Our ref: NO/2012/103476/02-L01
Your ref: 3/2012/0158
Date: 03 May 2012

**OUTLINE APPLICATION FOR THE ERECTION OF 73 OPEN MARKET
DWELLINGS AND 31 SOCIAL HOUSING PROPERTIES
SITE 2, BARROW BROOK BUSINESS VILLAGE, BARROW, CLITHEROE,
LANCASHIRE**

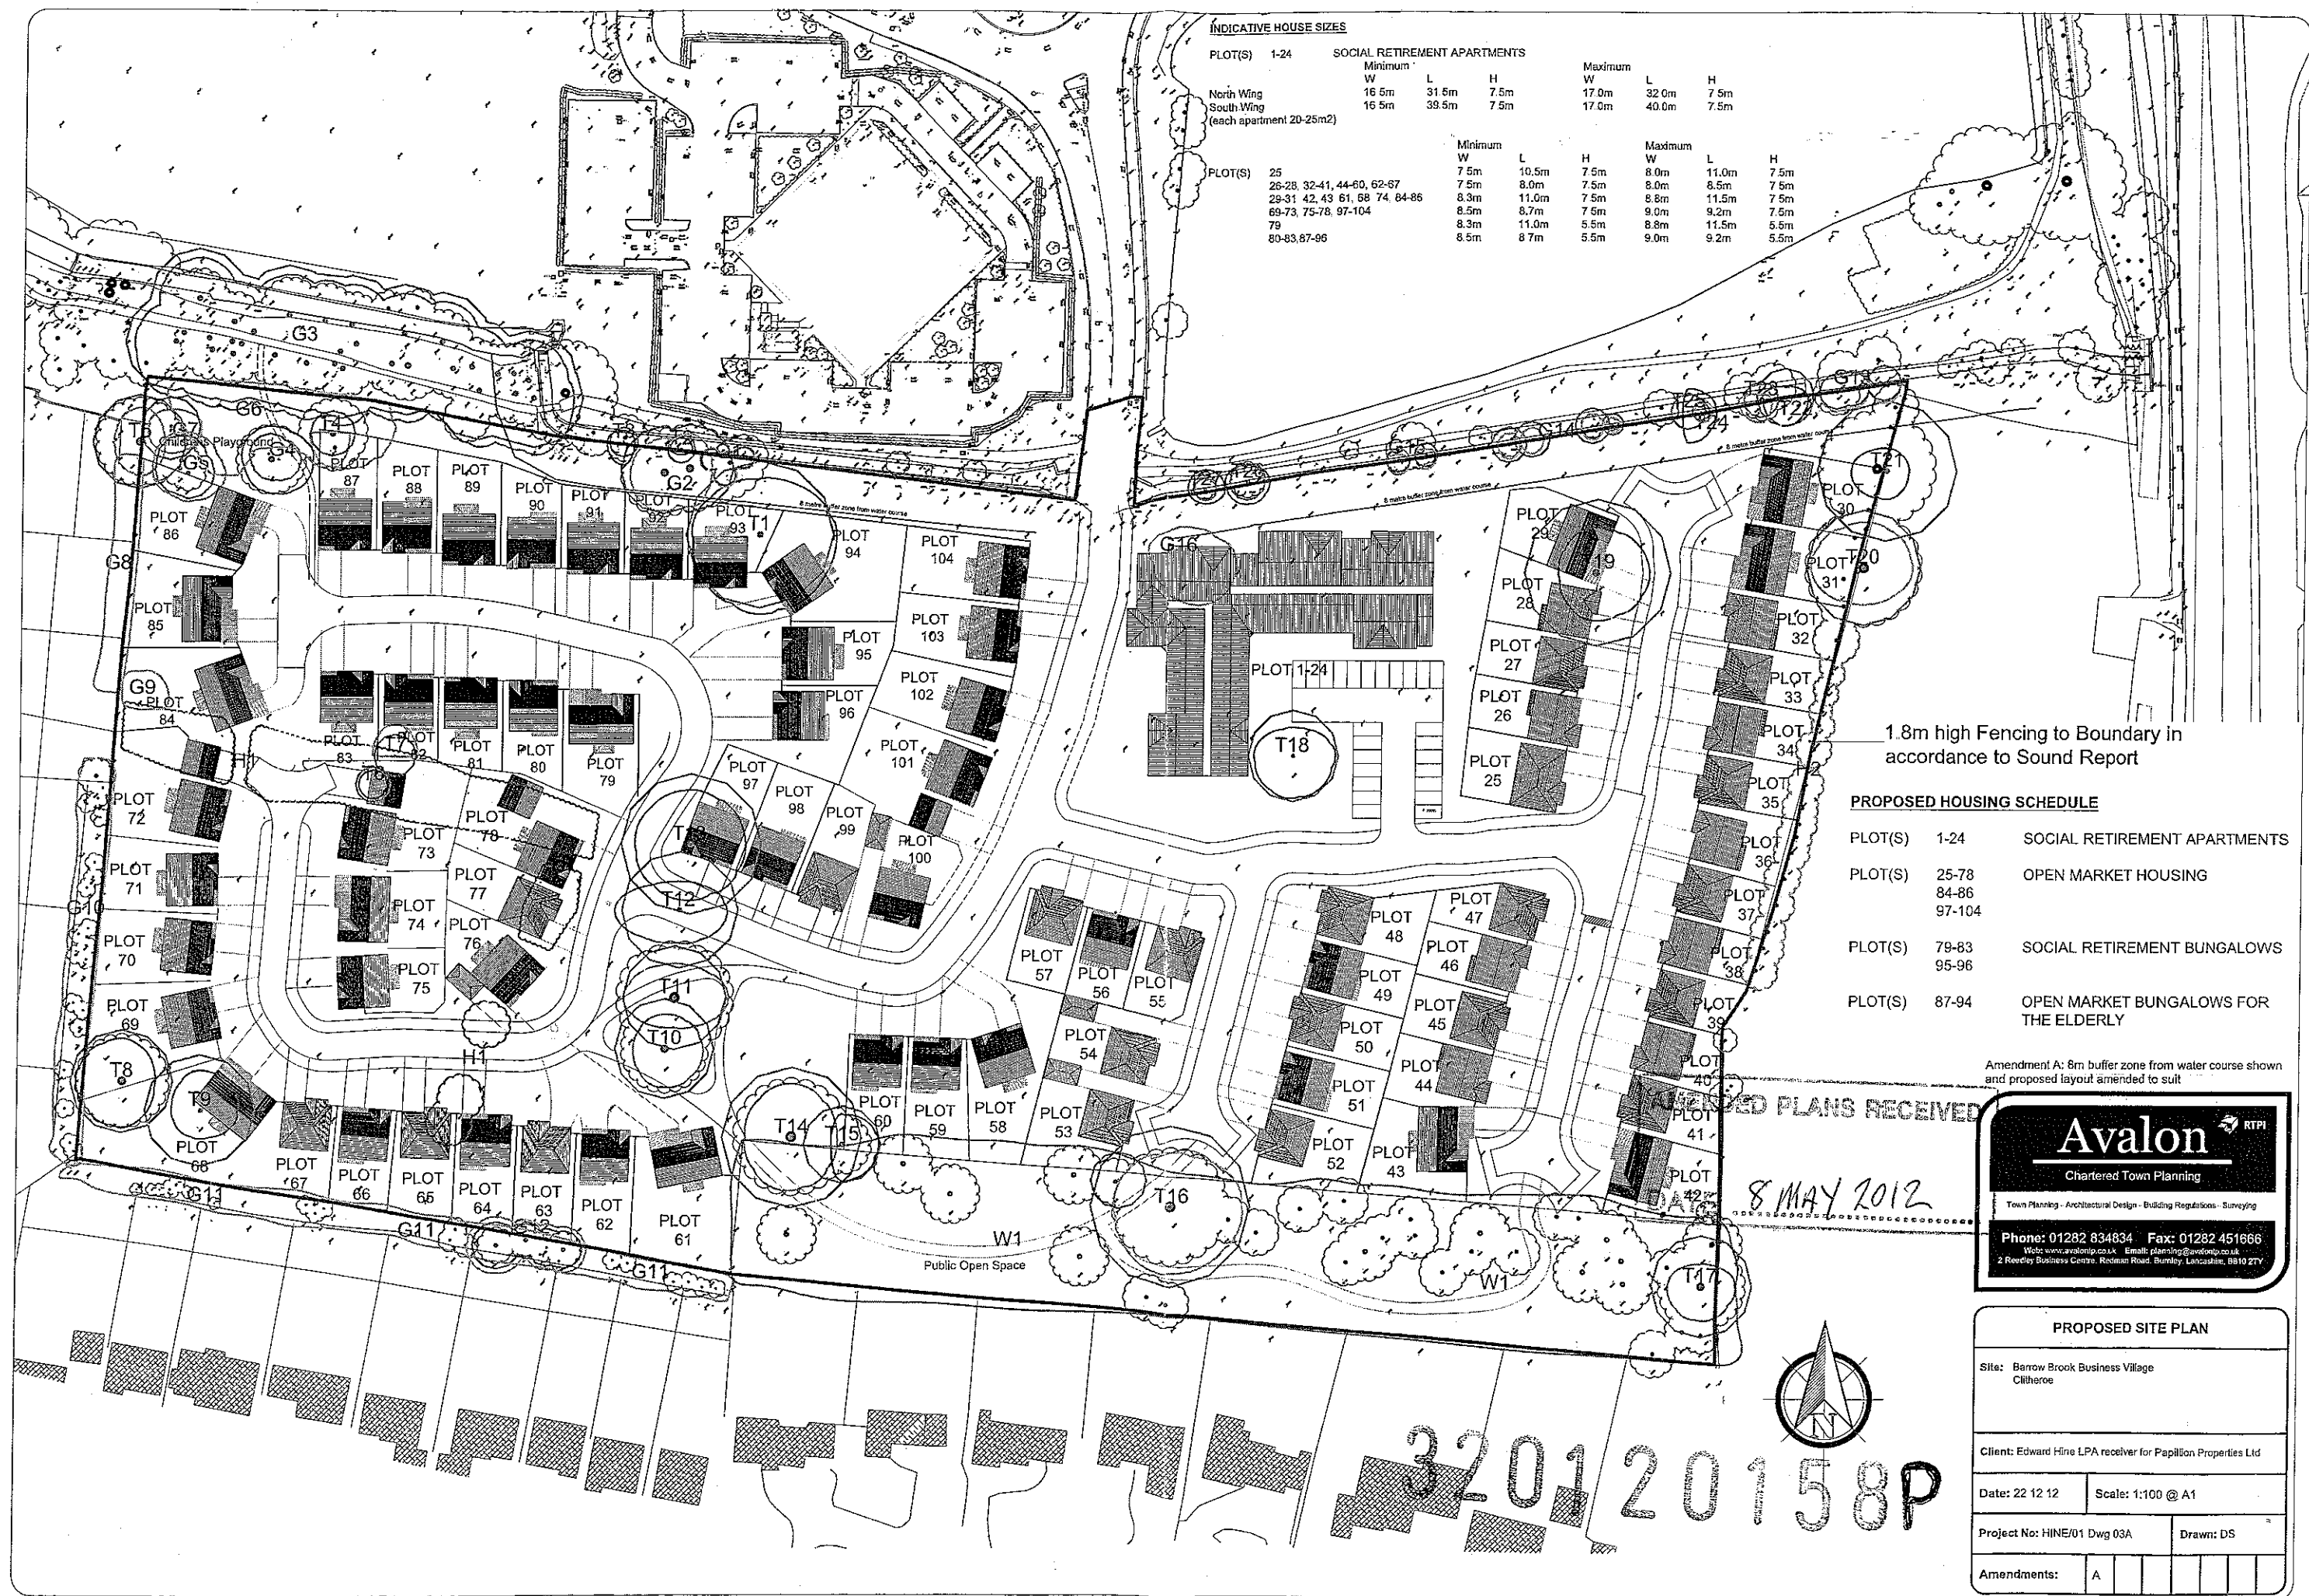
We are in receipt of a revised site layout (reference HINE/01Dwg 03A) from Avalon Town Planning. As requested, the revised plan now provides a buffer zone along the full length of the site which is free from development, including fences, structures and car parking. We therefore **withdraw our objection** to the proposed development.
